CUMBERLAND
CITY COUNCIL

OA2021/0004

Subject: State Significant Development Application (SSD-10470), Woolworths Warehouse and Distribution Centre Auburn
Application No: OA2021/0004
Property: 11 - 13 Percy Street Auburn
Proposal: Demolition of the existing structures and construction of a warehouse and distribution centre to operate 24 hours a day, seven days a week with associated earthworks, stormwater drainage, landscaping, car parking and business identification signage

Project
**PROPOSED WAREHOUSE DARK STORE
11-13 PERCY STREET, AUBURN NSW**
Title
OSD TANK PLAN, SECTIONS AND DETAILS

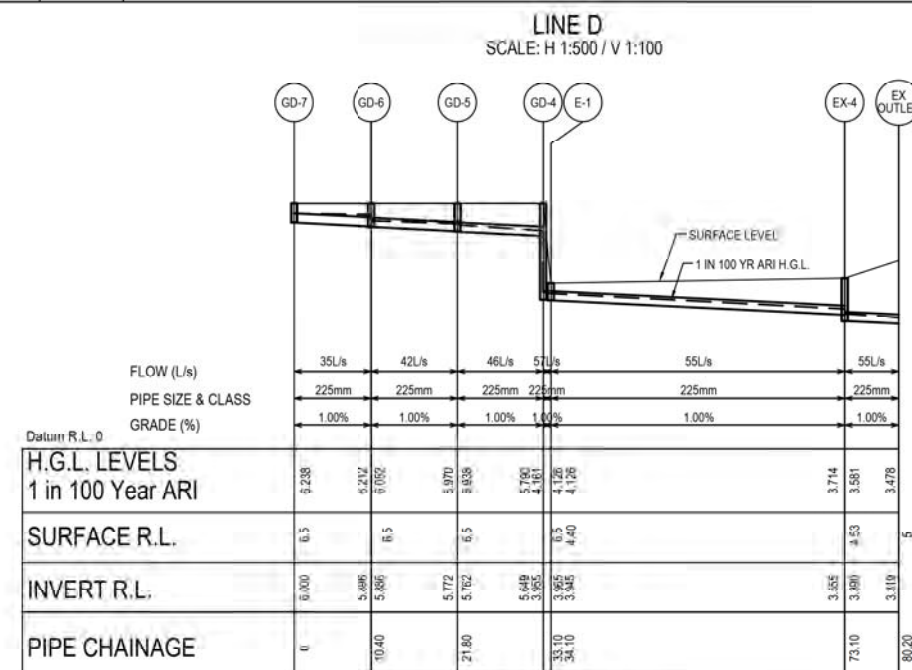
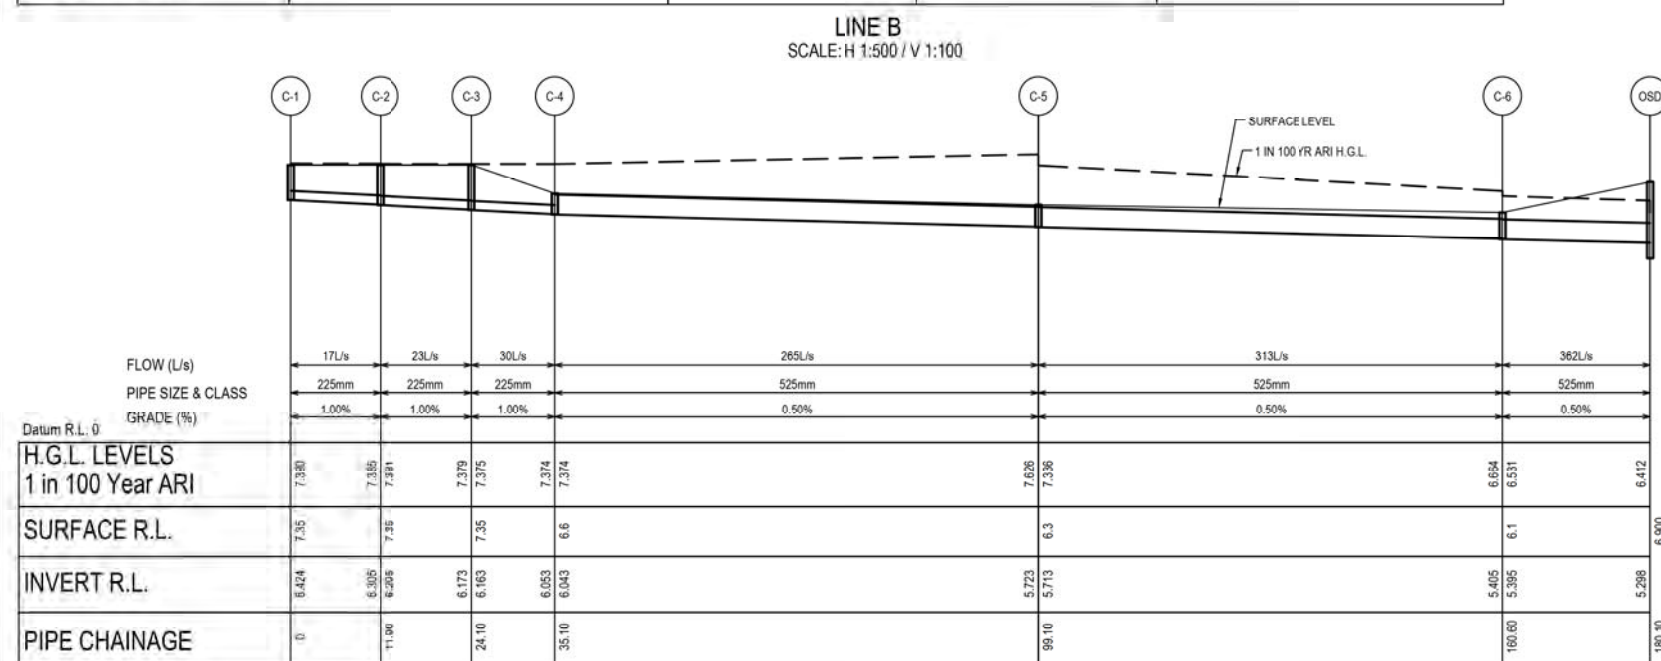
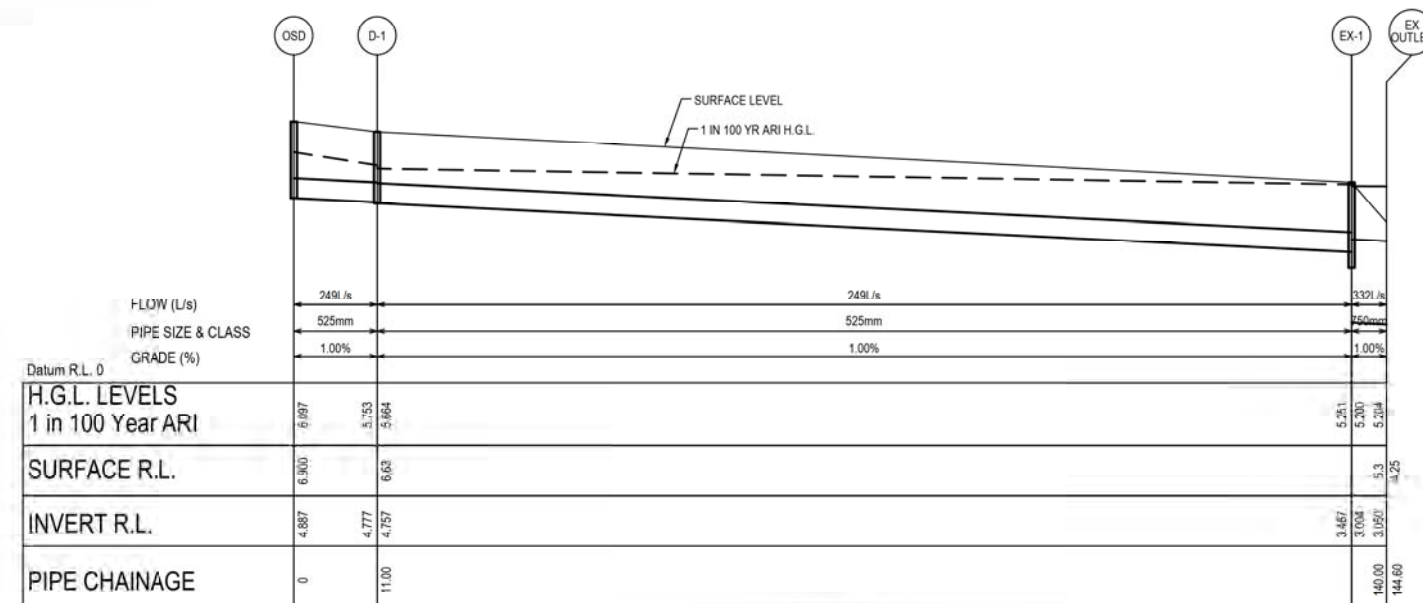
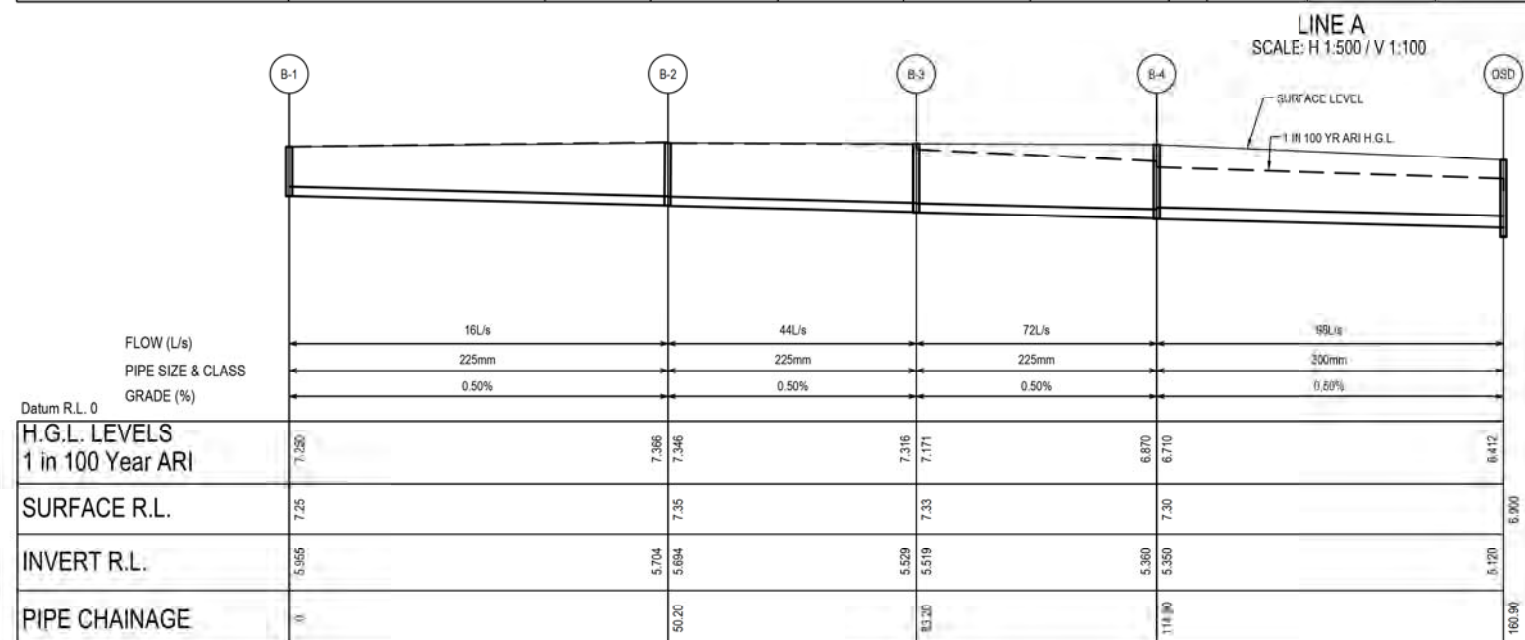
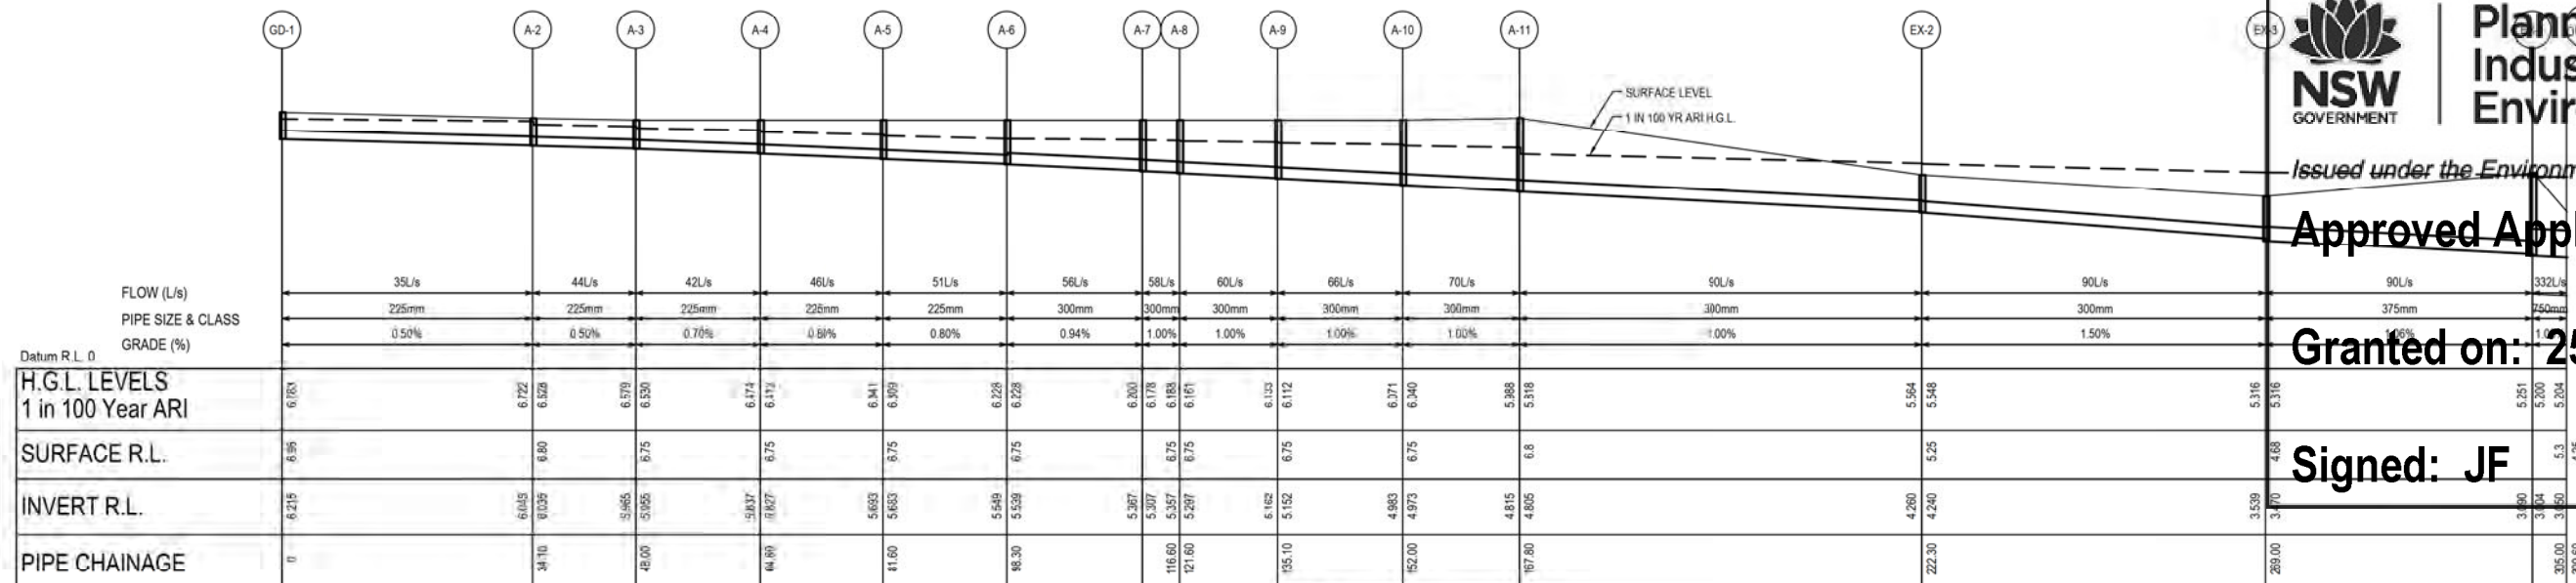
Stormwater drainage is considered to be satisfactory subject to the following:-

- a) Sydney Water consent shall be obtained for the stormwater disposal into the stormwater channel.
- b) It is noted that stormwater is discharged to the Sydney Water canal through the existing outlet. In this regard, the existing 750 pipe condition shall be checked and replaced if required subject to Sydney Water approval.
